Project Name: NORTH ALBUQ. ACRES UNIT B

**CITY OF ALBUQUERQUE
PLANNING DEPARTMENT
Development Review Board
March 24, 2004 Comments**

PROJECT # 1003299

RE: Lot 16A, Block 18, Tract A, N.A.A. Unit B/SPBP

**STARBUCK'S
EXTERIOR SIGNAGE**

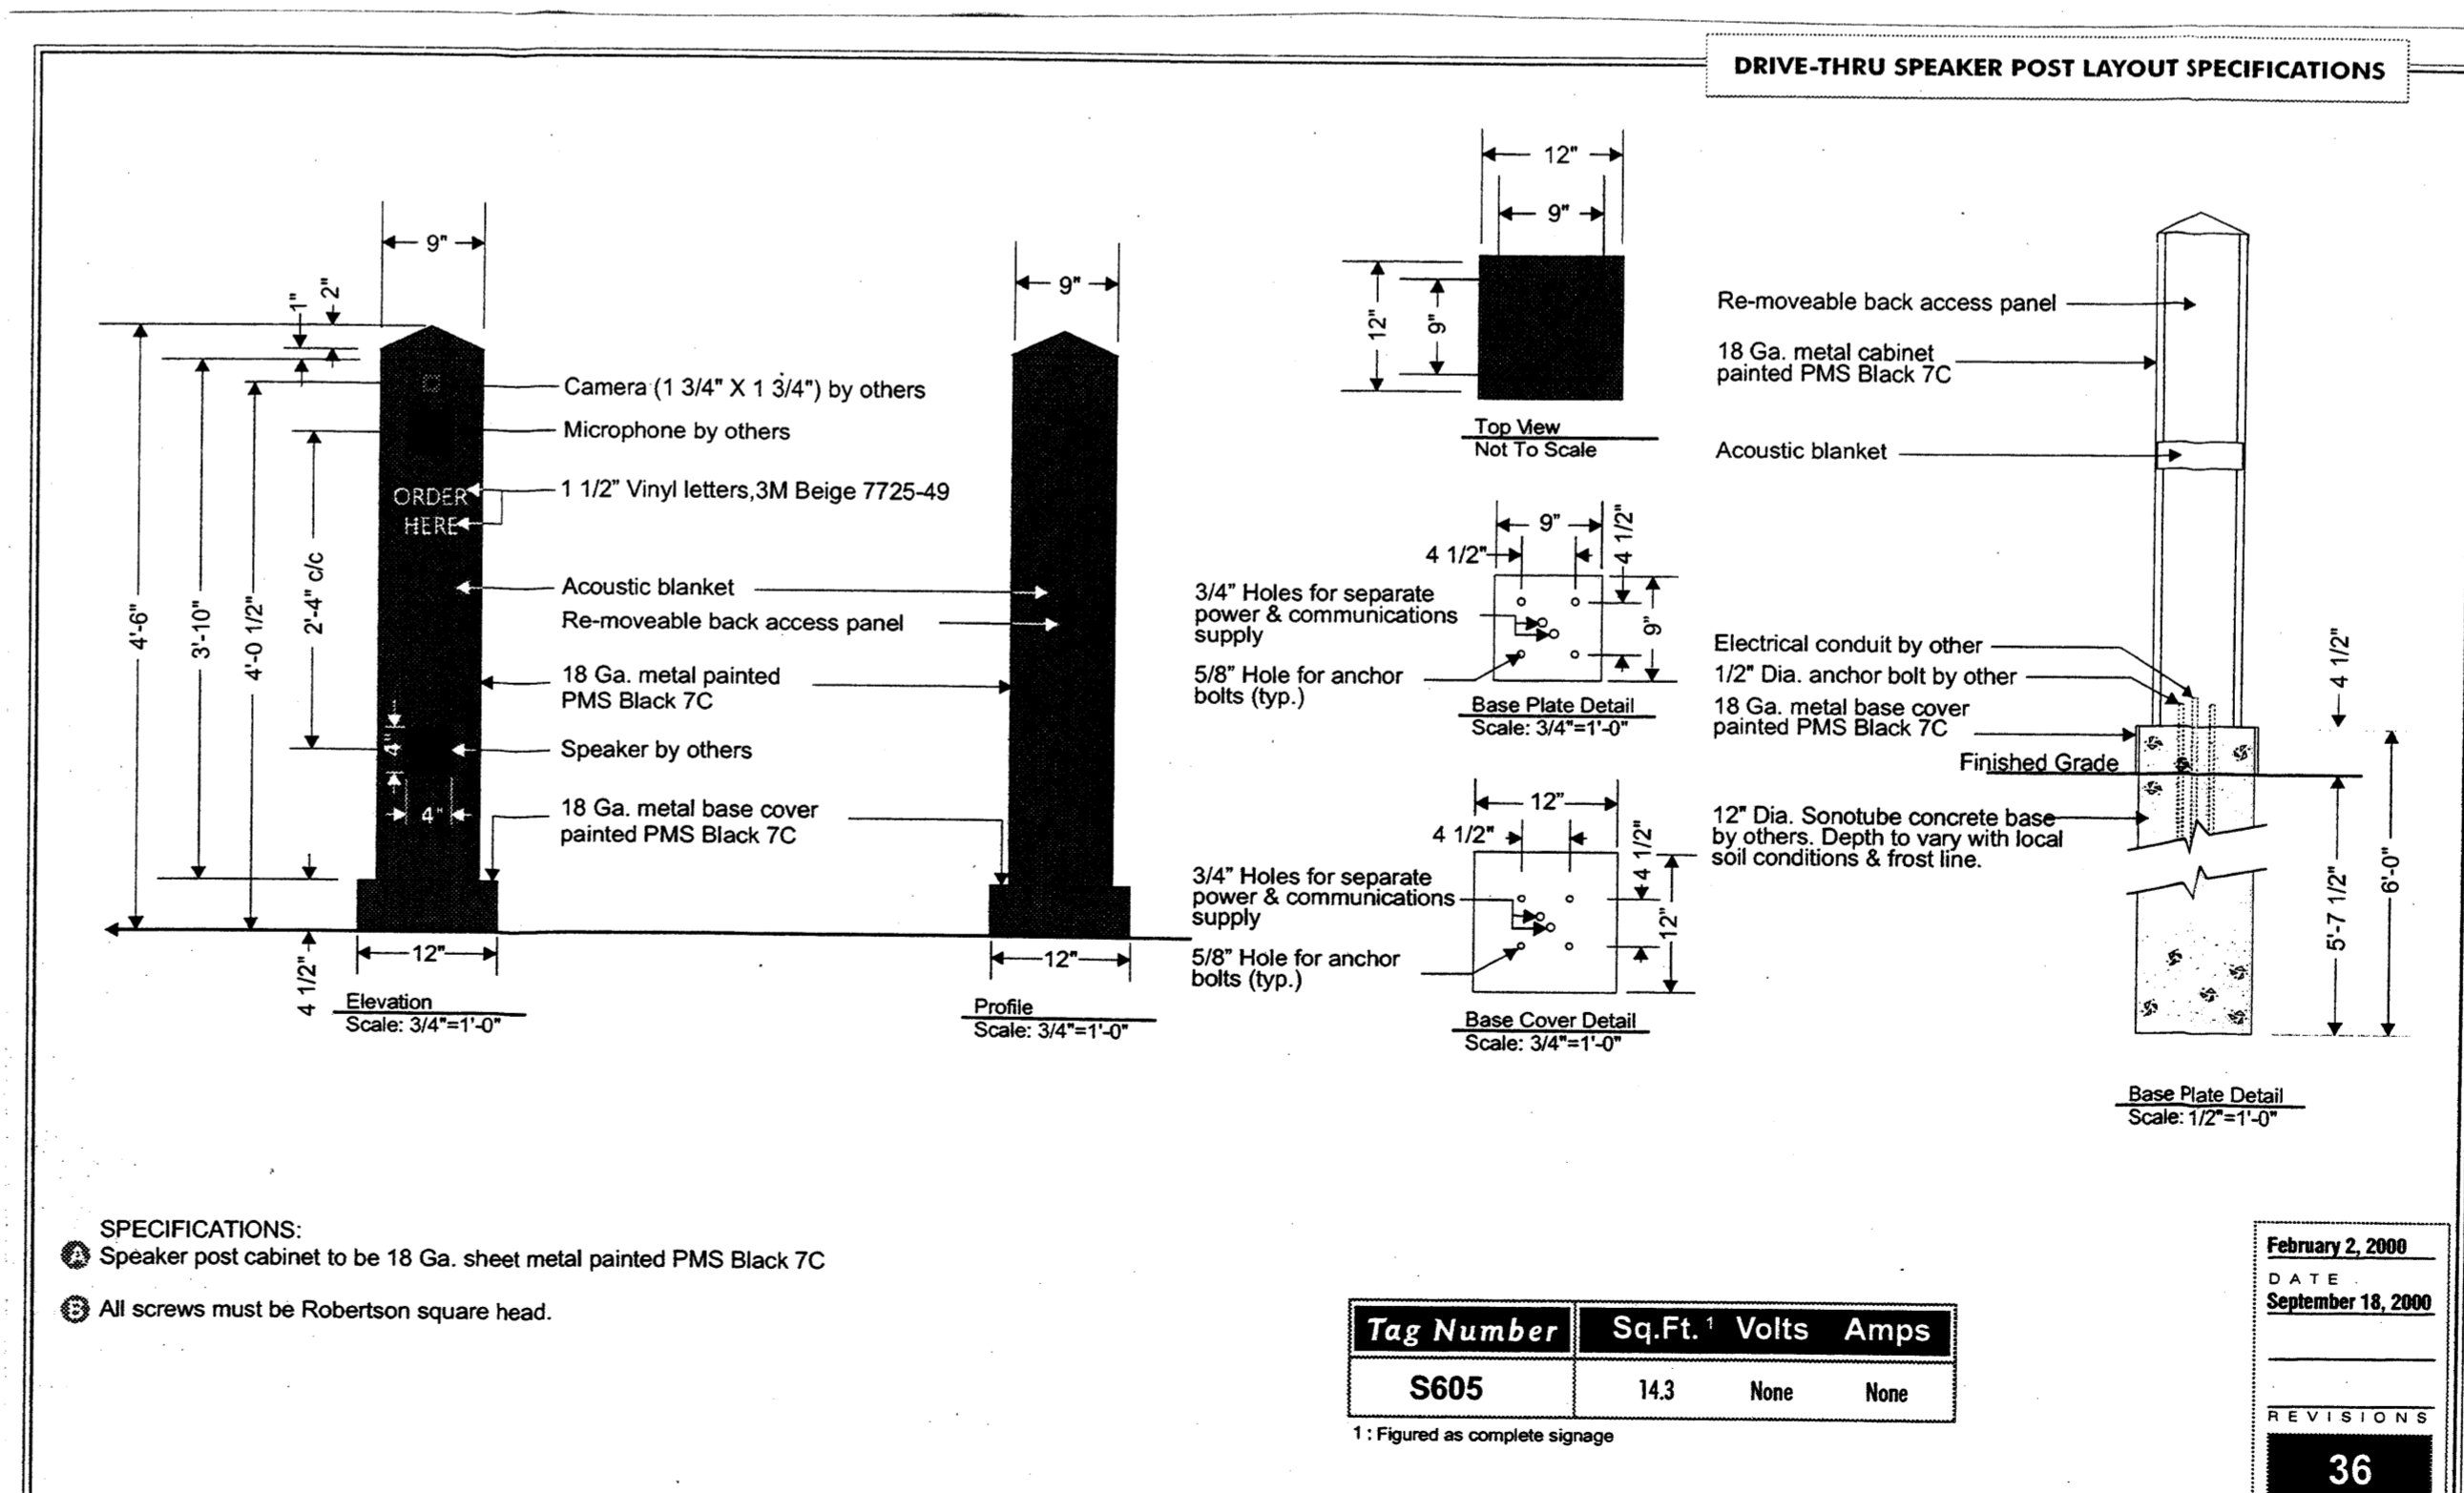
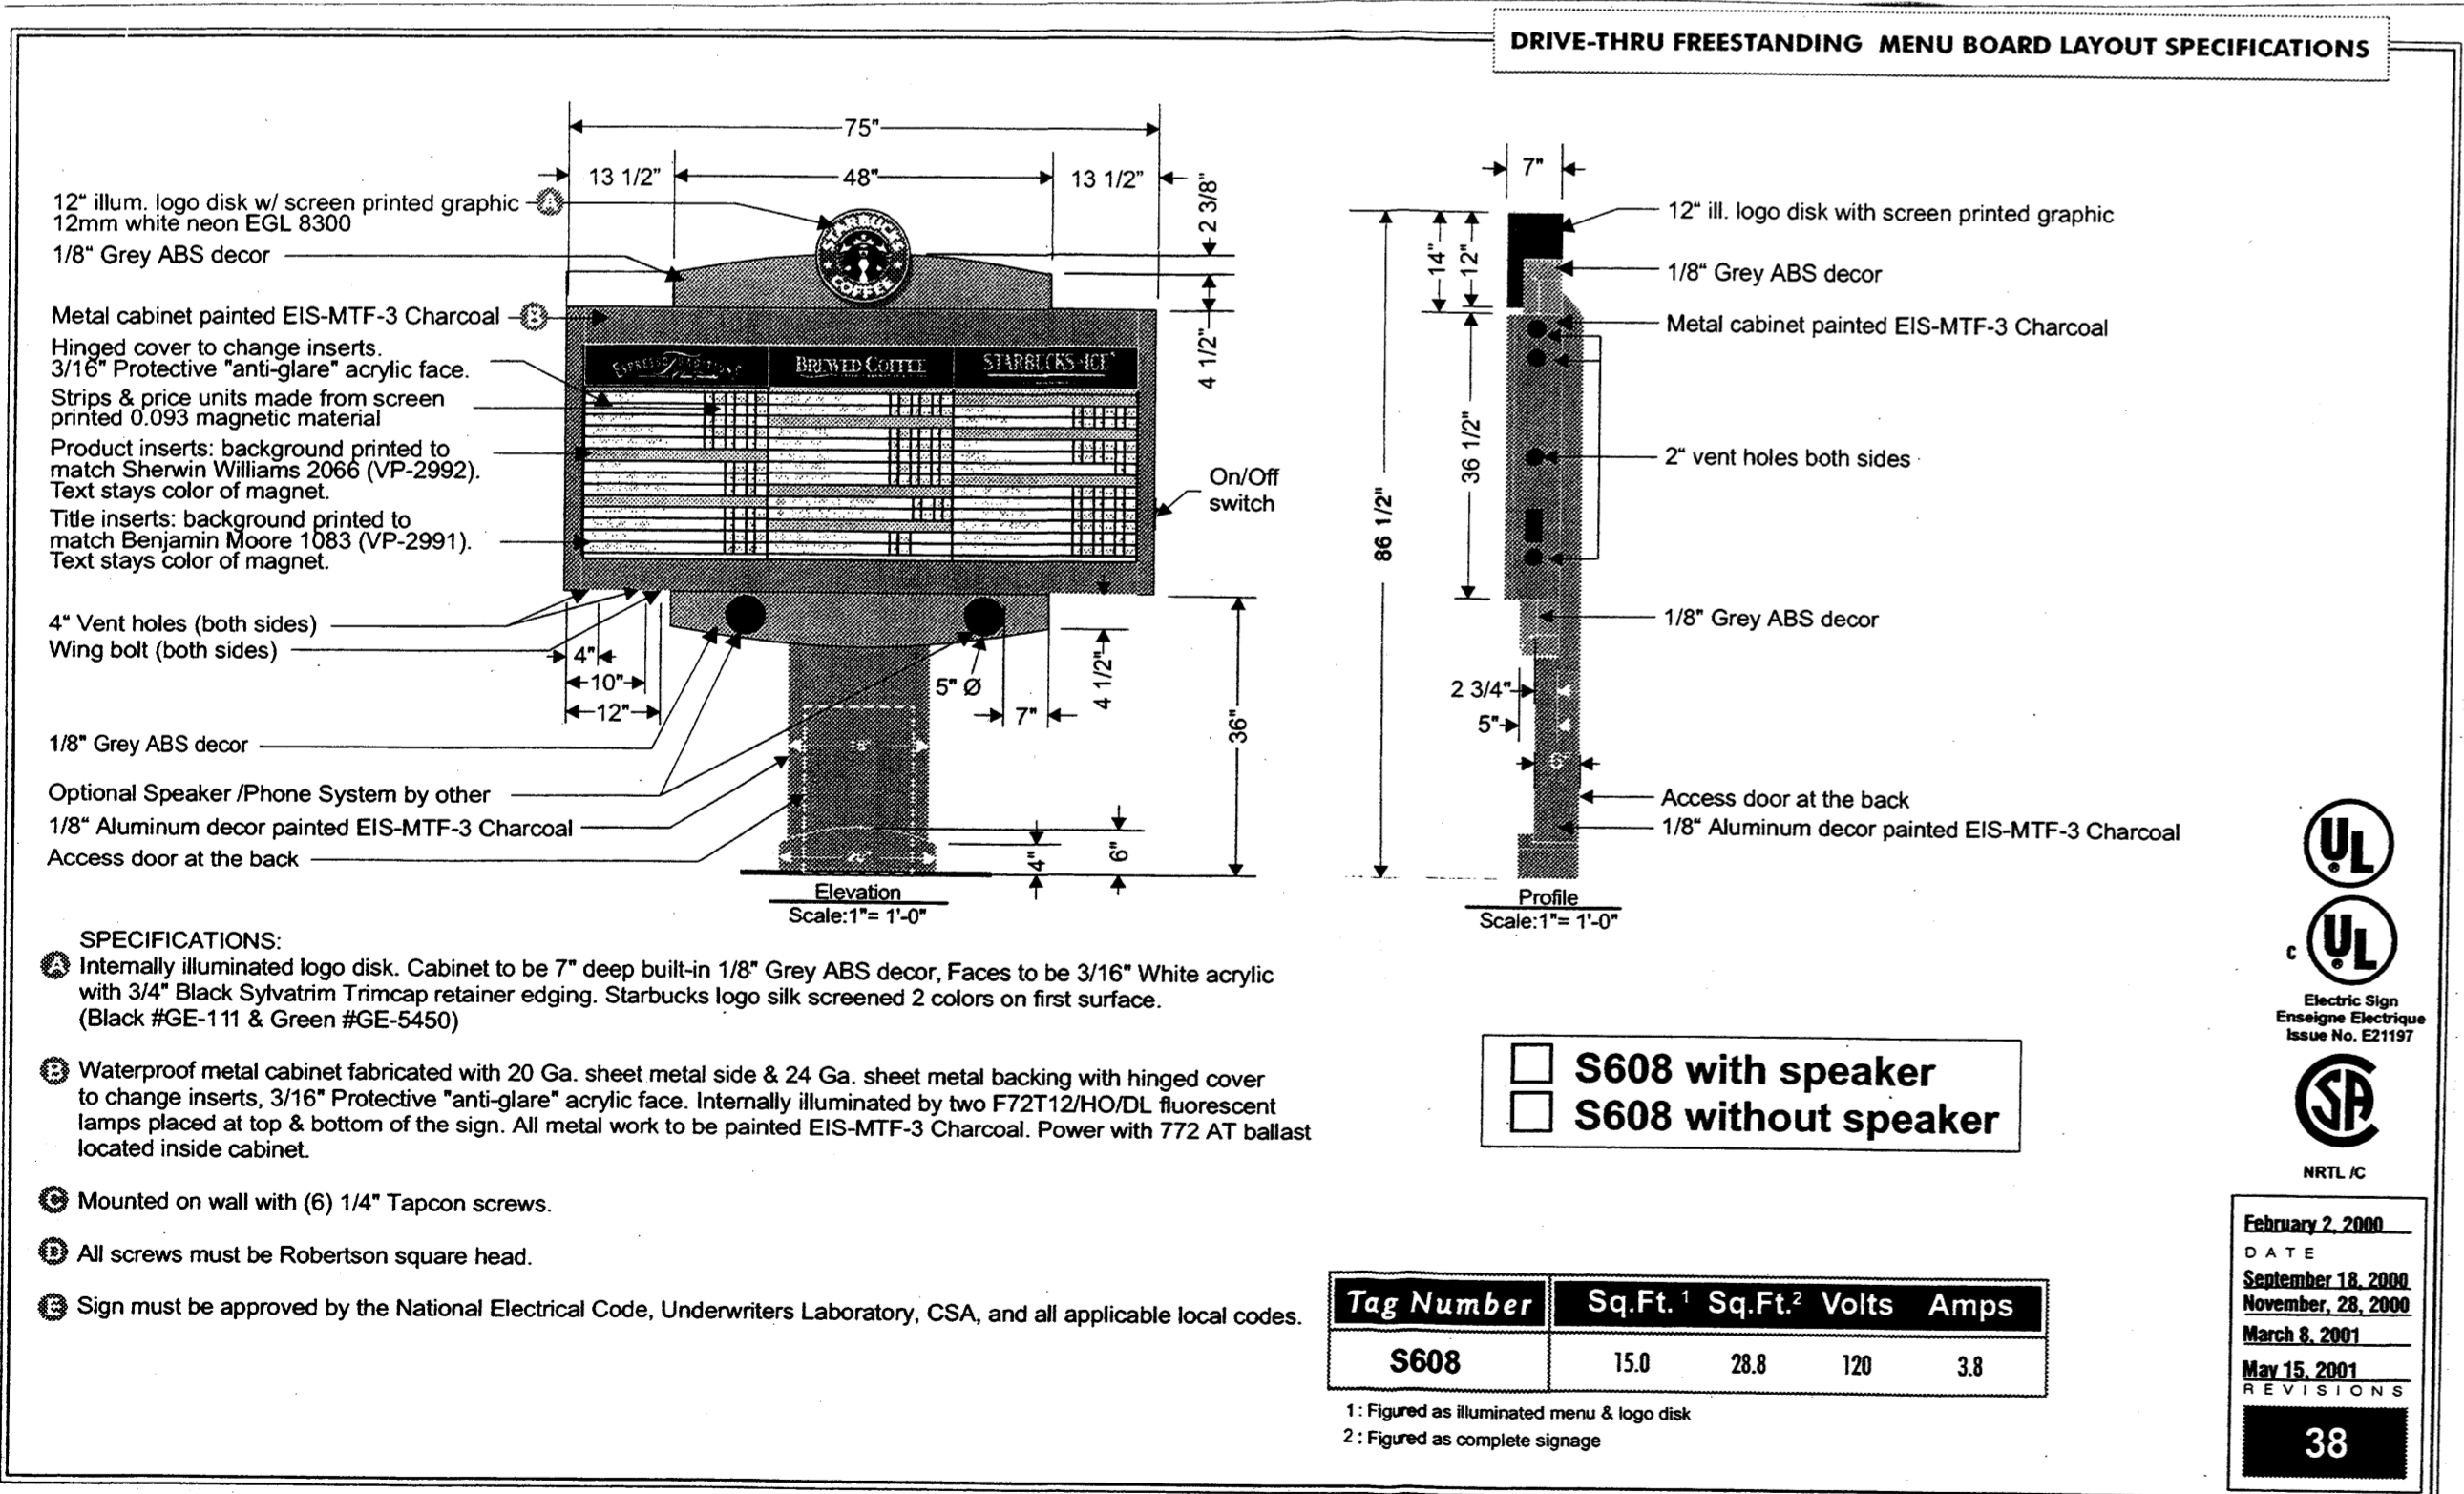
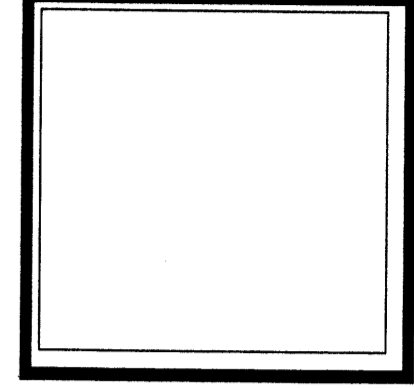
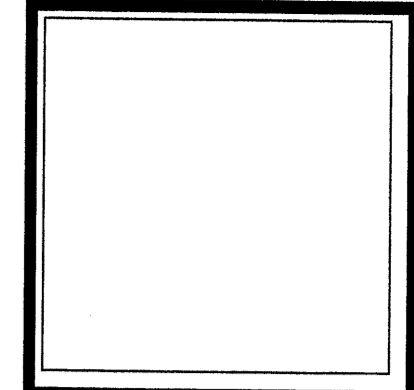
Signage. Materials & colors are required for the signs. The size complies with Established Urban requirements for C2 zoning, the requirement for North I25 Sector Plan.

EXTERIOR COLOR ELEVATIONS

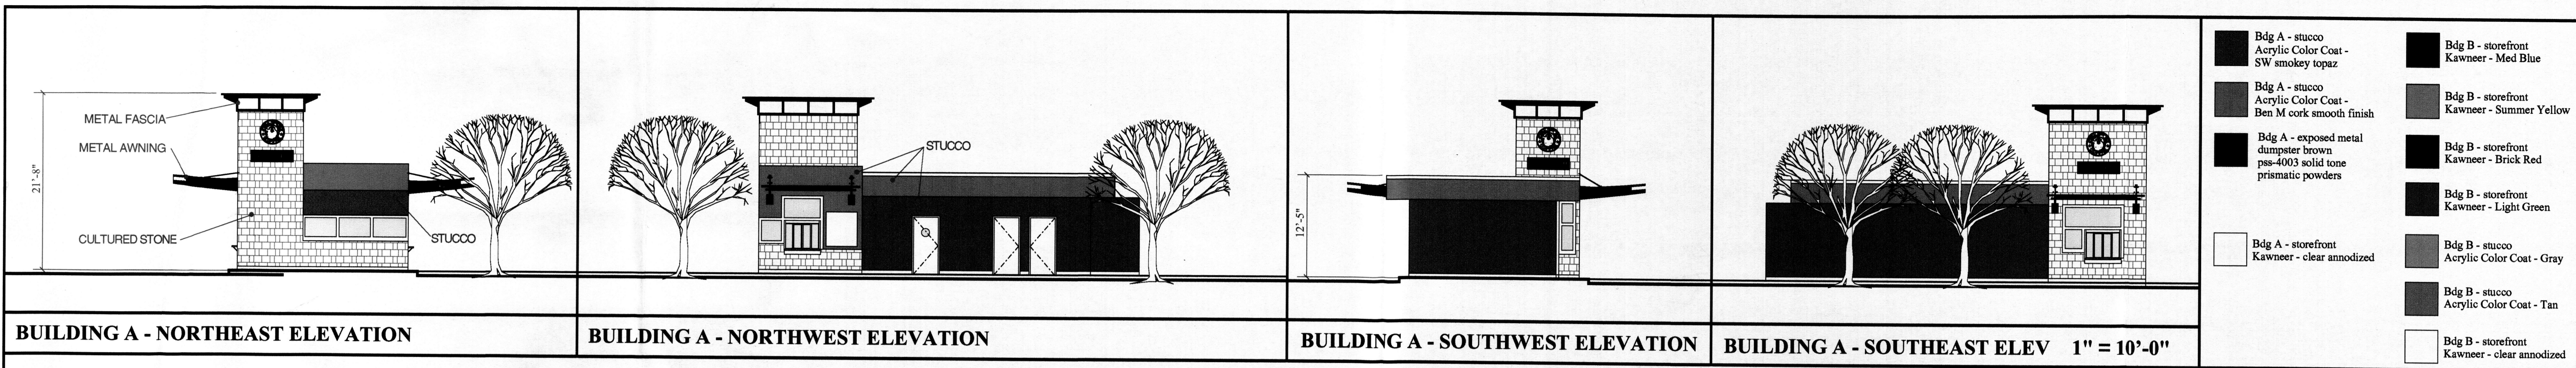
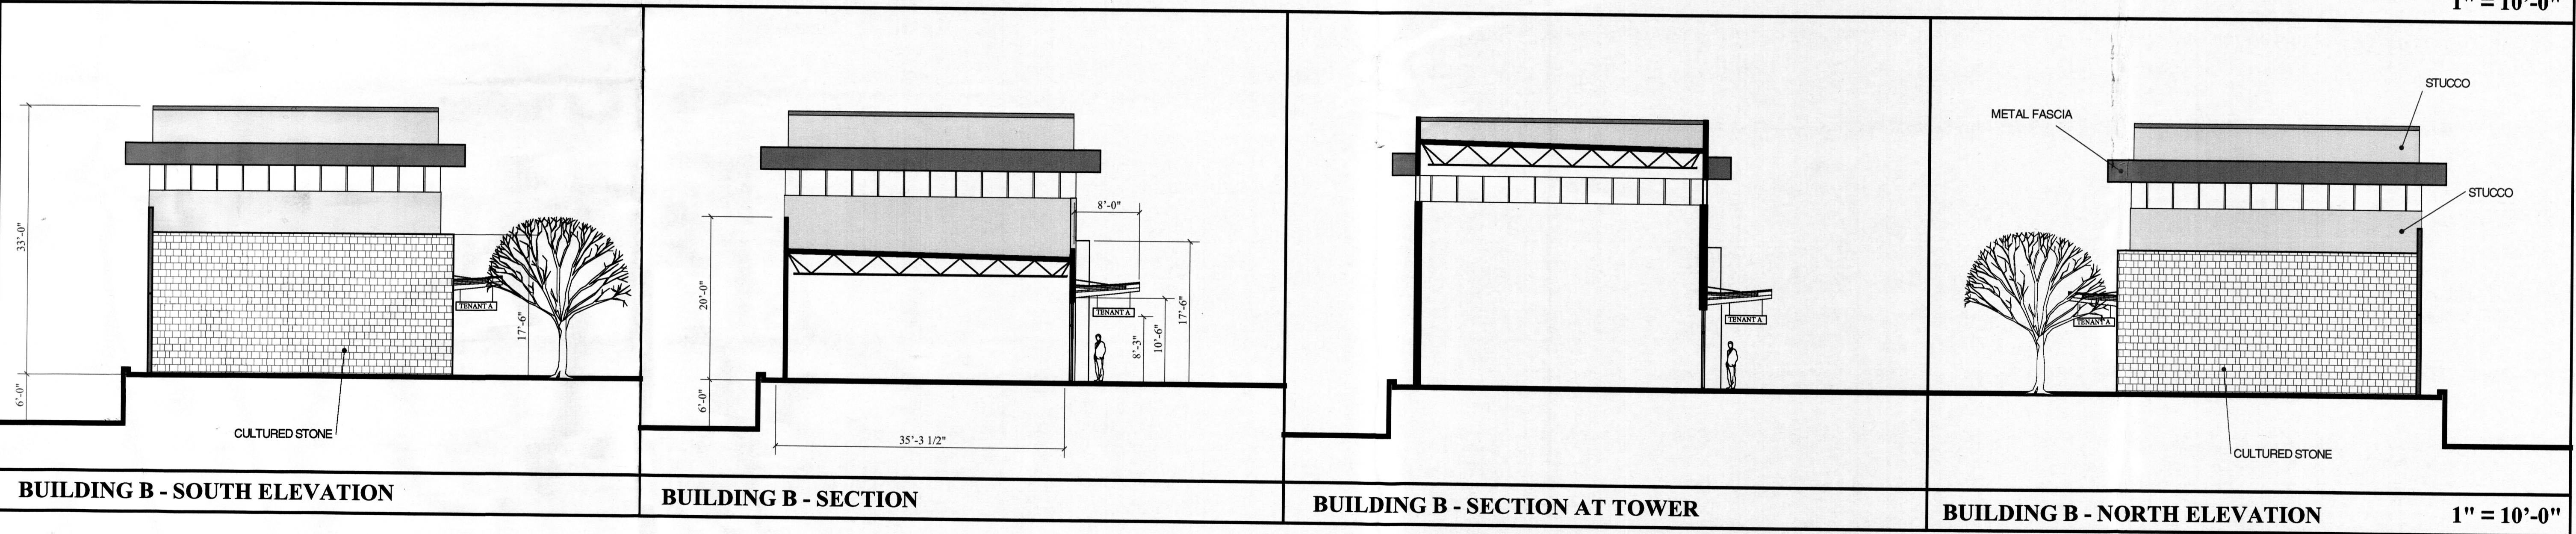
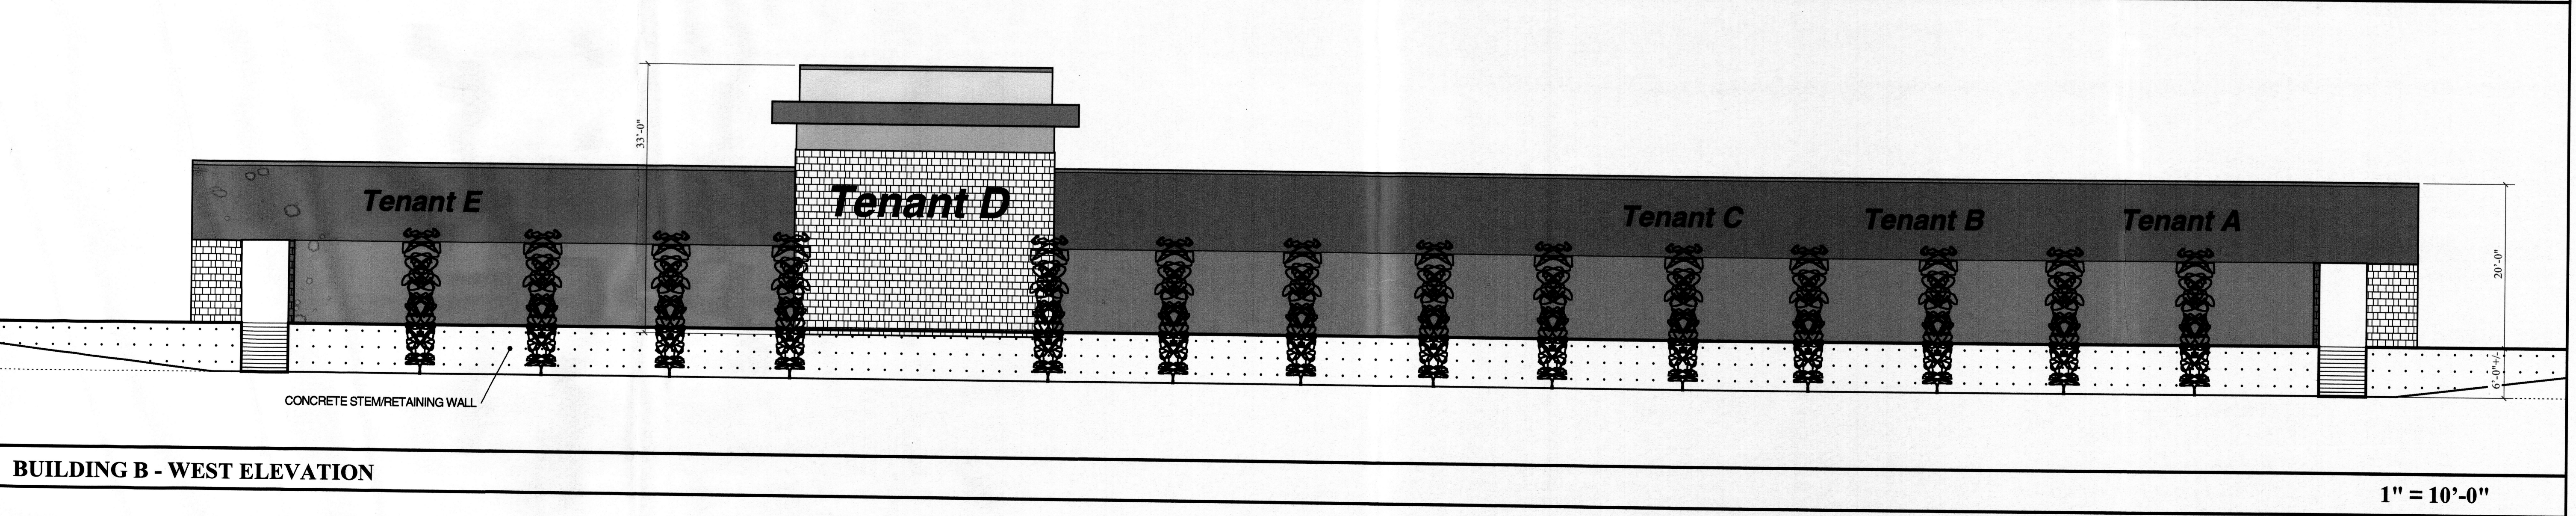
Building & Structure Elevations. Some of the requires detailed building elevations for each façade are missing. See Checklist.
